182186 -Priorsland Cherrywood SHD

**An Bord Pleanála Opinion Summary
Response**

Document Number: 182186-ABOSR-PL0

This document seeks to outline items raised by An Bord Pleanála (ABP) in their Opinion document that relate to the engineering aspects of the proposed development (ABP Reference ABP-307784-20). It also provides summary responses to the ABP comments and provides specific guidance to the relevant locations within the planning submission that actively address these issues.

PROPOSED EXTENSION TO EXISTING 01650 SURFACE WATER CULVERT

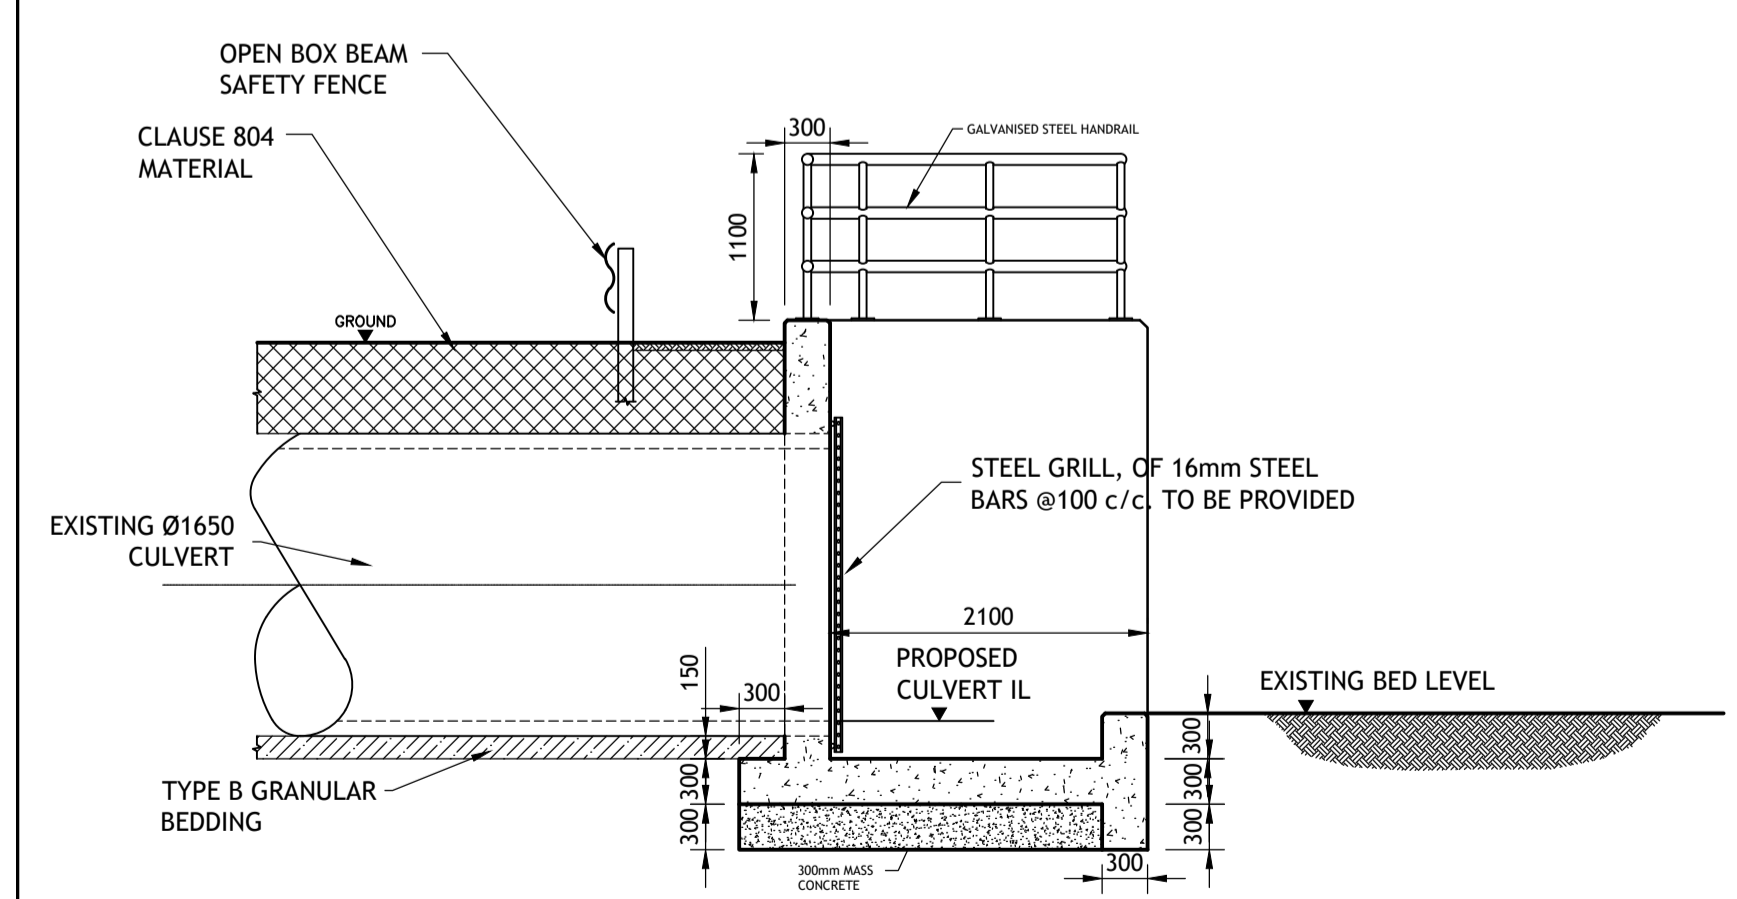
Ref No.	Page No.	ABP Comment	PUNCH Response
		<p>Flood Mitigation related DAPT conclusions:</p> <ul style="list-style-type: none"> DLRCC have carried out a feasibility assessment and have determined a preferred flood mitigation option to alleviate flooding in the Priorsland development area. The proposals as submitted are considered inconsistent with the requirements of the Planning Scheme and the DAPT will require that the applicant fully demonstrates in a further submission how their proposed design compares to DLRCC's preferred flood mitigation option and how their design mitigates flood risk not only for the subject development site but for the surrounding Priorsland development area and for the Common's Road area downstream. Notwithstanding the above, the DAPT consider proposals to discharge the extended flood relief culvert to a ditch as unacceptable and it is considered that further and detailed justification is also required from the applicant for the interim solution proposed in place of full completion of the northern food relief culvert. Notwithstanding the above, the DAPT consider proposals that omit flood containment on the norther side of the Carrickmines River as unacceptable and will require that flood containment on the northern side of the Carrickmines River, as detailed in the Planning 	<ul style="list-style-type: none"> It is noted that DLRCC commissioned Consulting Engineers RPS in 2018 to carry out a feasibility assessment and determine the most effective flood mitigation option to alleviate flooding in the Priorsland development area which forms part of the Cherrywood Strategic Development Zone. A total number of nine flood mitigation options were assessed and one option, deemed the preferred option, was recommended on the basis of providing the most favourable outcome. <p>Please note that this feasibility assessment has absolutely no statutory or planning status and so does not govern the Planning Scheme requirements.</p> <p>Following review of the outline RPS proposals by PUNCH, we note that the proposed works associated with the preferred option would contravene a number of key ecological/environmental requirements associated with the SDZ and the DLRCC Development Plan, which render this option completely unviable. Refer to SSFRA Section 3.7 for further details.</p> <p>The flood mitigation proposals as presented in this planning application and associated SSFRA are consistent with the requirements of the Planning Scheme, whereas the DLRCC 'preferred option' is demonstrably not compliant.</p> <ul style="list-style-type: none"> There are no proposals to “discharge the extended flood relief culvert to a ditch”. The proposals are to extend the

Ref No.	Page No.	ABP Comment	PUNCH Response
		<p>Scheme and progressed in DLRCC’s preferred flood mitigation option, is addressed in an amended design and revised SSFRA.</p> <ul style="list-style-type: none"> Refer to the conclusions and recommendations contained in the JBA report entitled “2020s1114 - Review of site-specific Flood Risk Assessment” in Appendix B. JBA conclude that the information provided under the SSFRA submitted is insufficient to determine that Flood Risk is appropriately addressed onsite and elsewhere through the provision of proposed mitigation measures for this development. JBA also conclude that as the site is within Flood Zone A and B. the Justification Test is required by the Planning Guidelines to be applied and satisfactorily passed and the lack of detail in the SSFRA submitted has not demonstrated that the conditions of the Justification Test has been met. The DAPT require that exceedance flows are addressed in a further submission. The DAPT require that full details of the proposed basement network are provided in a further submission. 	<p>flood relief culverts back into the Carrickmines Stream at downstream locations (entirely consistent with the CPS).</p> <ul style="list-style-type: none"> As demonstrated in the SSFRA protection to the lands to the north of Carrickmines Stream is granted by the existing topography. Please refer to Appendix A for drawing extracts from the DLRCC/RPS feasibility assessment. Please further note that the proposed introduction of raised bunds as proposed under DLRCC’s ‘preferred option’ would eliminate the entirety of the riparian habitat and preserved mature tree line (including mature Turkey Oaks) to the north of Carrickmines Stream. Furthermore, the dredging of the flood plain to the south would similarly destroy all riparian habitat to the south of Carrickmines Stream - all completely contrary to the environmental/ecological requirements of the CPS and other statutory authorities such as Inland Fisheries Ireland and National Parks and Wildlife Services. It is also noted that the introduction of discrete berms as flood protection in a flood plain, with residential development to the rear is absolutely not acceptable protection for such development under the requirements of “The Planning System & Flood Risk Management Guidelines”. Respectfully, the feasibility assessment commissioned by DLRCC seems to consider the hydraulic nature of the flood mitigation and does not consider the myriad other factors/issues that must be addressed in a holistic design solution. Please refer to the SSFRA, which provides sufficient detail and adequately addresses flood risk and the associated mitigation of flooding in accordance with the requirements
